Norfolk Vanguard Offshore Wind Farm

Appendix 29.2

Consultation Responses

Applicant: Norfolk Vanguard Limited
Document Reference: 6.2.29.2
RHDHV Reference: PB4476-005-0292
Pursuant to: APFP Regulation 5(2)(a)

Figure: 29.9a	Drawing No: PB4476-005-029-009				
Revision:	Date:	Drawn:	Checked:	Size:	Scale:
07	15/05/2018	LA	JP	A3	1:4,000
08	04/06/2018	LA	JP	A3	1:4,000

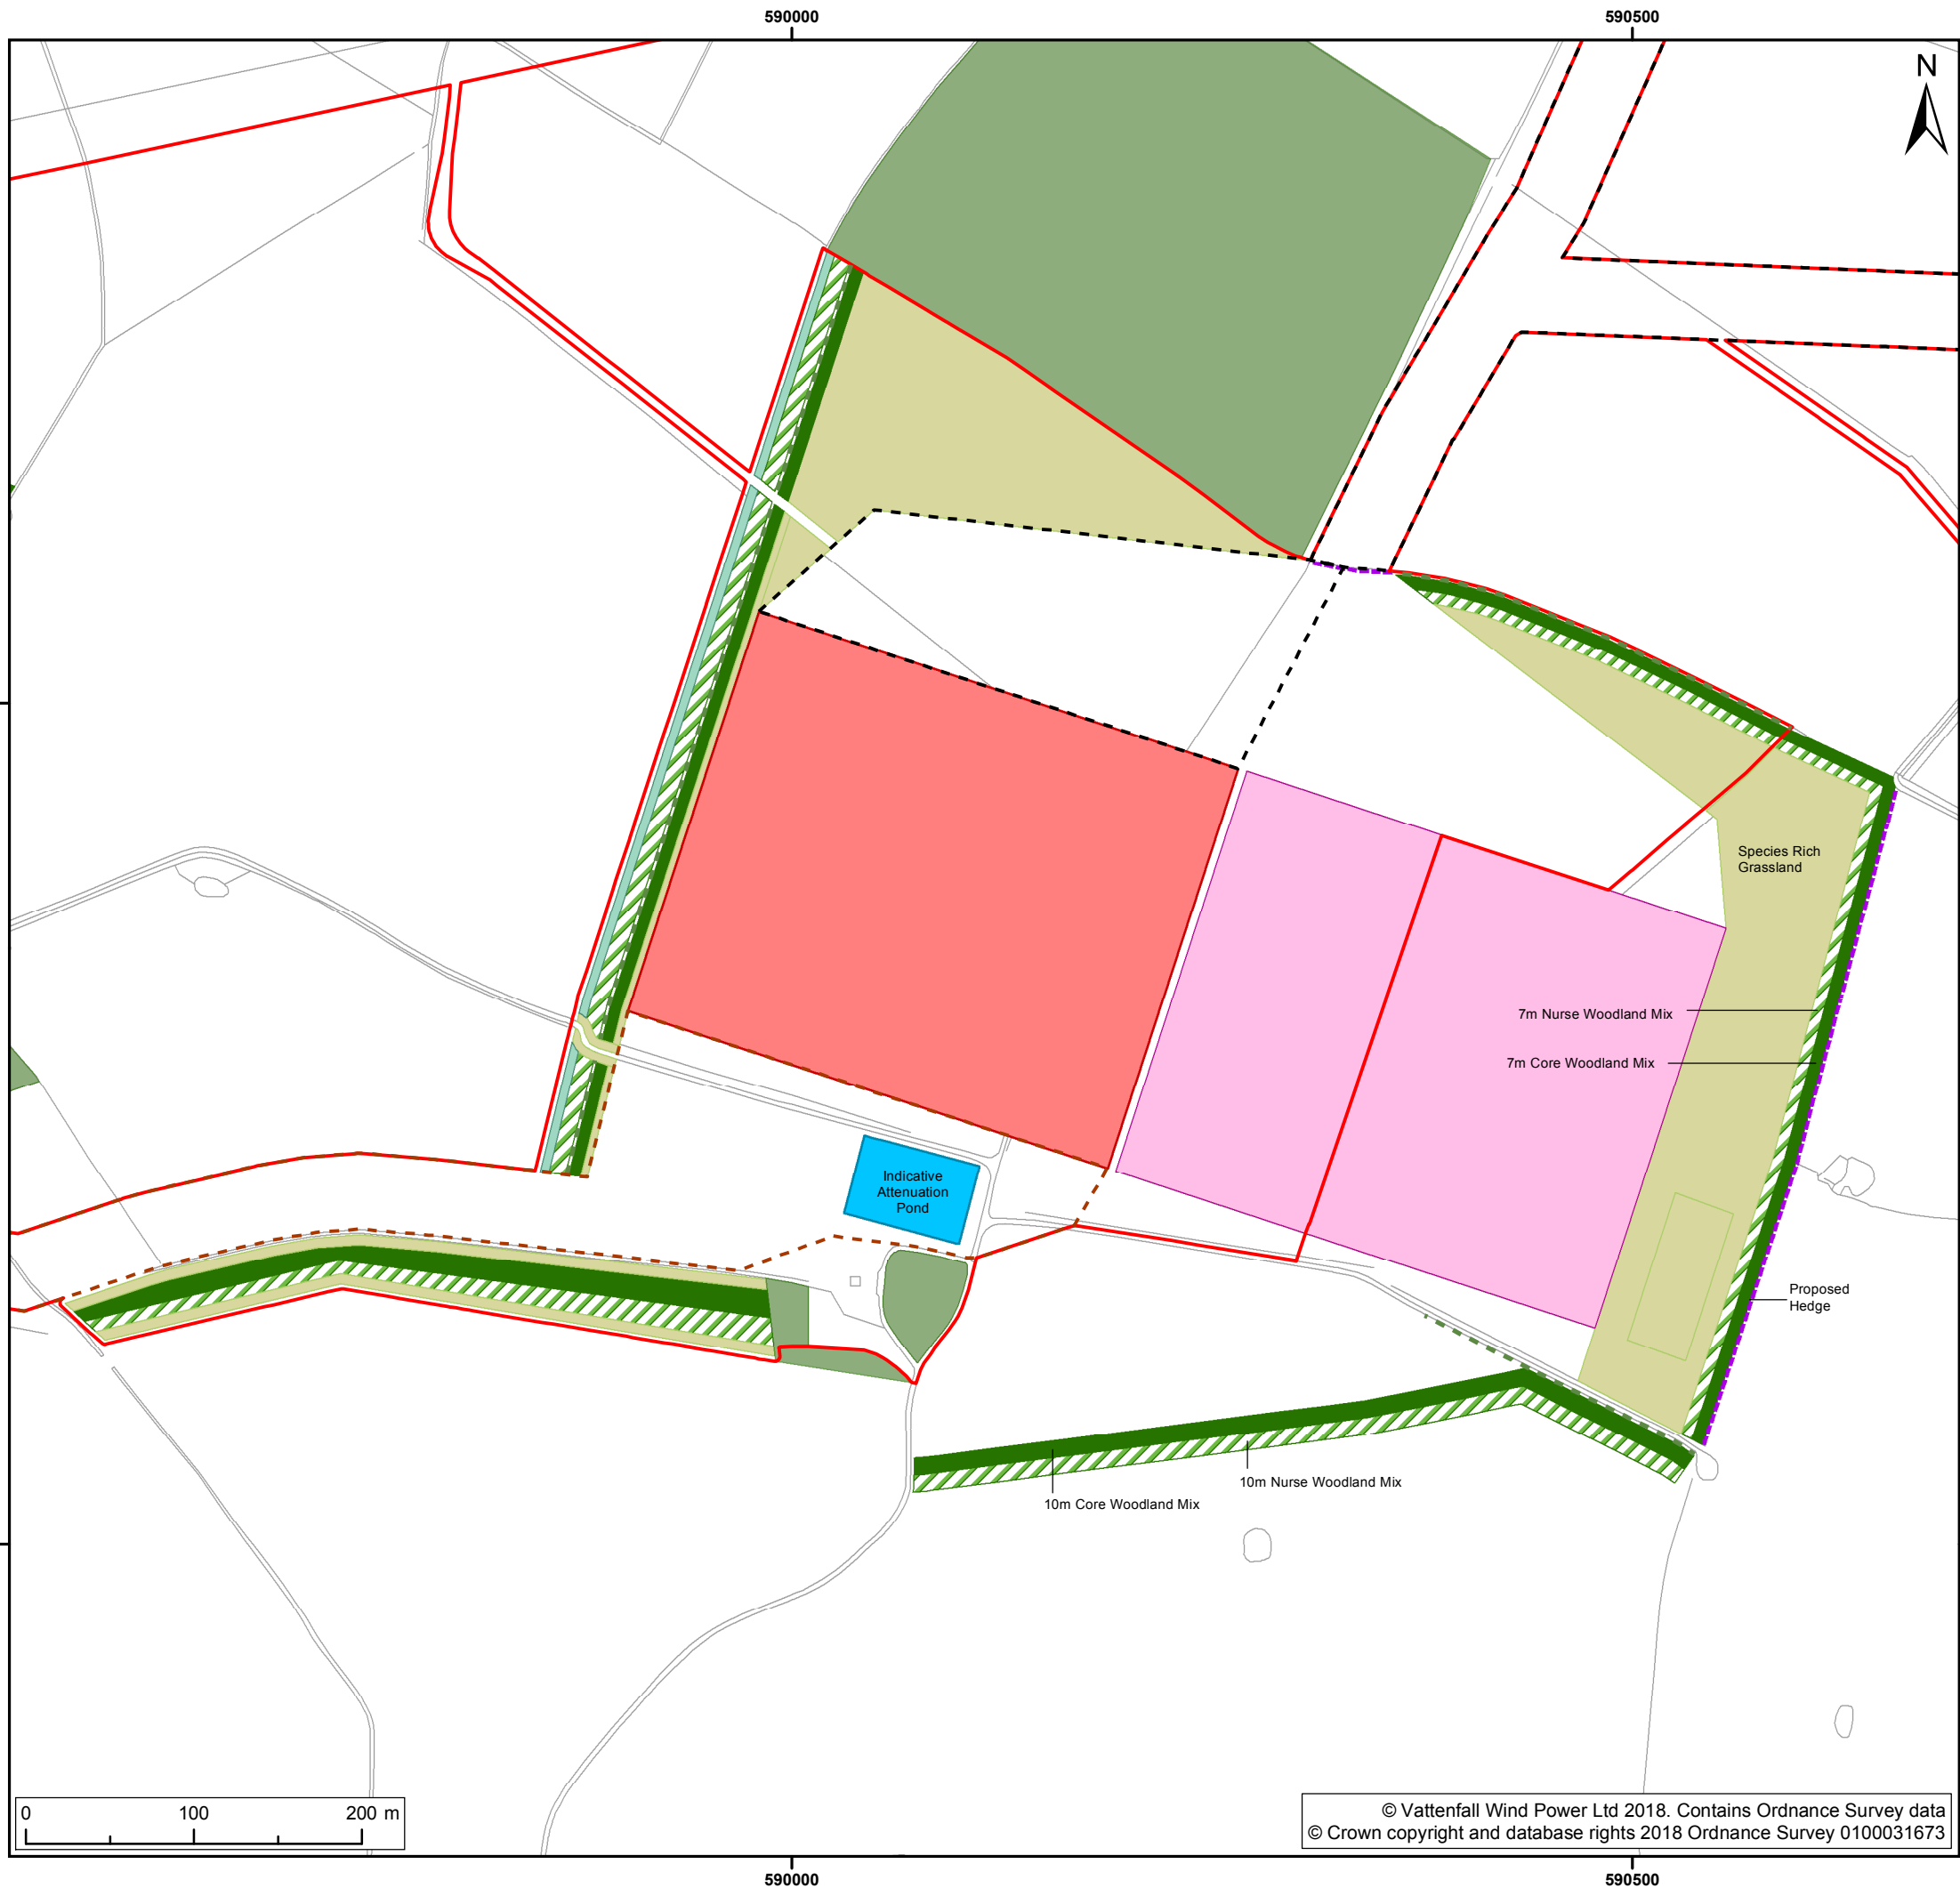
Natural England	PEIR Review December 2017	We support advance planting where possible to mitigate for visual impacts followed by post-construction planting.	Mitigation planting shown in Figures 29.9 to 29.12 maximises opportunities to implement advance planting. The OLEMS (document reference 8.7) contains detailed information on mitigation planting.
Natural England	PEIR Review December 2017	Chapter 29 Landscape and Visual Impact Assessment sets out the considerations for assessment however the District Council's adopted Landscape Character Assessment SPD (2013) should be included in the list of documents to have regard to.	Norfolk and Suffolk Brecks Landscape Character Assessment (2013) has been included within the references in section 29.6.3.
Natural England	PEIR Review December 2017	We note that site reconnaissance has shown that the potential impact of the project on the Norfolk Coast AONB would be severely limited by a combination of distance, low landform	Noted.

North Norfolk District Council	PEIR Review December 2017	In terms of long term and permanent effects on the landscape, there will be a need to provide appropriate landscape mitigation particularly where open cut trenches affect field boundaries and landscape features such as mature trees. Vattenfall has indicated they will seek to do this but this would need to be set out within the mitigation strategy. Where possible, the District Council would expect Horizontal Directional Drilling (HDD) to be used if routes through sensitive woodlands or landscapes cannot be avoided.	The majority of hedgerows removed as part of the onshore cable route construction would be replanted apart from in select locations where technical constraints restrict replanting. No semi-natural broadleaved woodland would be removed and under a worst-case only up to 3.9Ha of plantation woodland would be removed. Additional sites using HDD have been included to ensure all County Wildlife Sites are avoided. Figure 29.9a, 29.10b and 29.11b show mitigation planting for the onshore project substation, National

Figure: 29.23a	Drawing No: PB4476-004-029-023				
Revision:	Date:	Drawn:	Checked:	Size:	Scale:
04	15/05/2018	LA	JP	A3	Multiple
05	04/06/2018	LA	JP	A3	Multiple

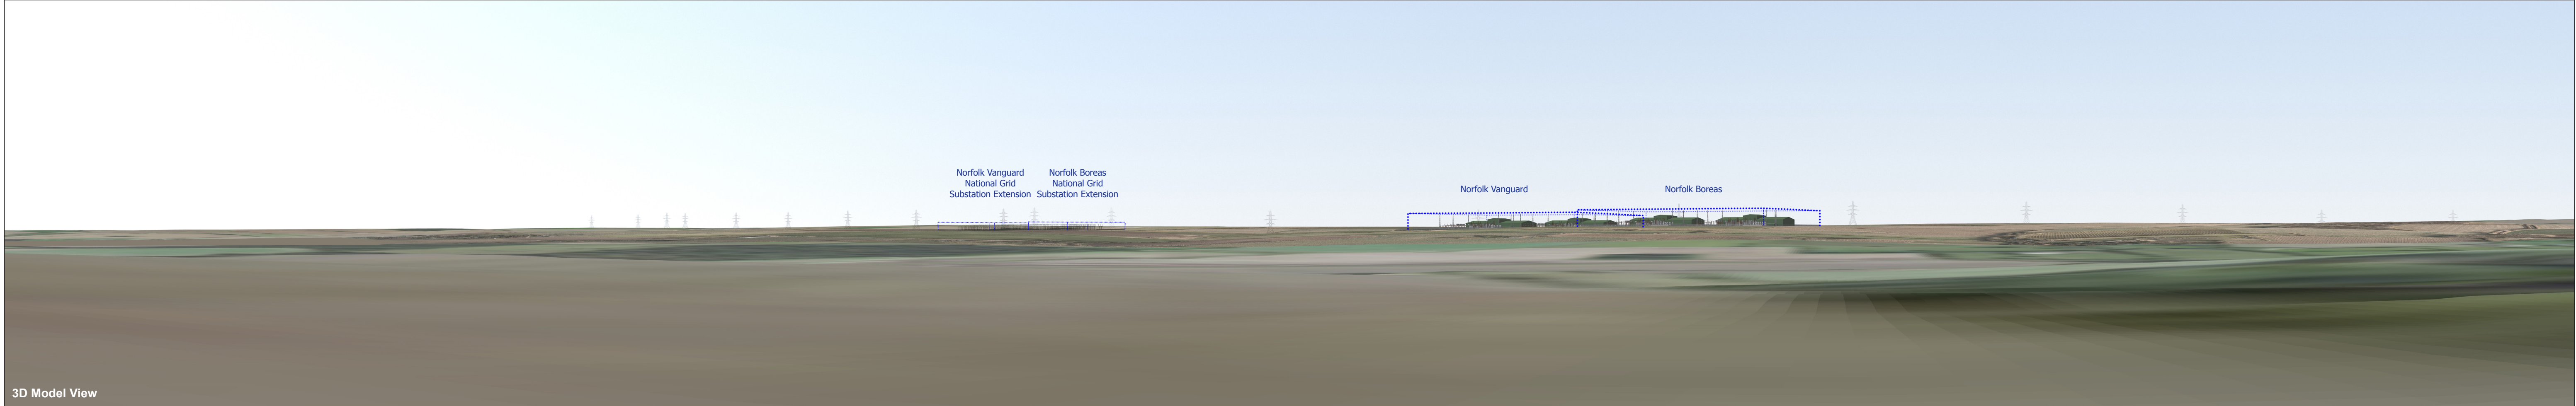
Consultee	Date /Document	Comment	Response / where addressed in the ES
			produced in compliance with industry standards and verified on site. Visualisations are presented in Figures 29.13-29.24. Appendix 29.1 LVIA Methodology describes the process of verification.
SoS	Scoping Opinion November 2016	In response to the proposal to scope out cumulative effects in respect of the landfall and onshore cable route at all phases of the project: The Secretary of State agrees with this approach for operation and decommissioning; however, as the projects to be considered in the CIA have not yet been determined, the SoS does not agree that construction phase cumulative impacts can be scoped out at this stage.	As requested, the cumulative effects of the landfall and onshore cable route during the construction phase are assessed in Chapter 29 Landscape and Visual Impact Assessment section 29.88 with particular consideration of the Norfolk Boreas project.

Consultee	Date /Document	Comment	Response / where addressed in the ES
		per annum for nurse species would be more realistic. Size of stock has not yet been proposed and should include a mixture.	These growth rates have been applied in the visualisations in Figures 29.13 to 29.24 to show the height of mitigation planting after a 20 year period.
North Norfolk District Council	PEIR Review December 2017	Aftercare of planting is a key component of landscape mitigation measures and will be critical to the predicted success of the schemes proposed. This does not appear to have been outlined at this stage but should be fully itemised.	Maintenance of planting is covered in the OLEMS (document reference 8.7) and more detailed guidance will be developed prior to planting implementation.
North Norfolk District Council	PEIR Review December 2017	The District Council recommends that further work needs to be undertaken by Vattenfall to identify those hedgerows / field boundaries that would benefit from trenchless techniques to ensure that these important ecological and landscape features can be retained. This is critical as compensatory planting will not be able to include replacement trees over the buried cable routes.	Through selection of HVDC technology, the width of the onshore cable route has been reduced from 45m to 20m where it crosses hedgerows. The majority of hedgerows removed would be replanted, apart from in select locations where technical constraints restrict replanting. Trees would not be replaced above the cables, nor within a 6m to 10m wayleave either side of the 20m working width. These parameters are assessed in Chapter 29 Landscape and Visual Impact Assessment section 29.7.
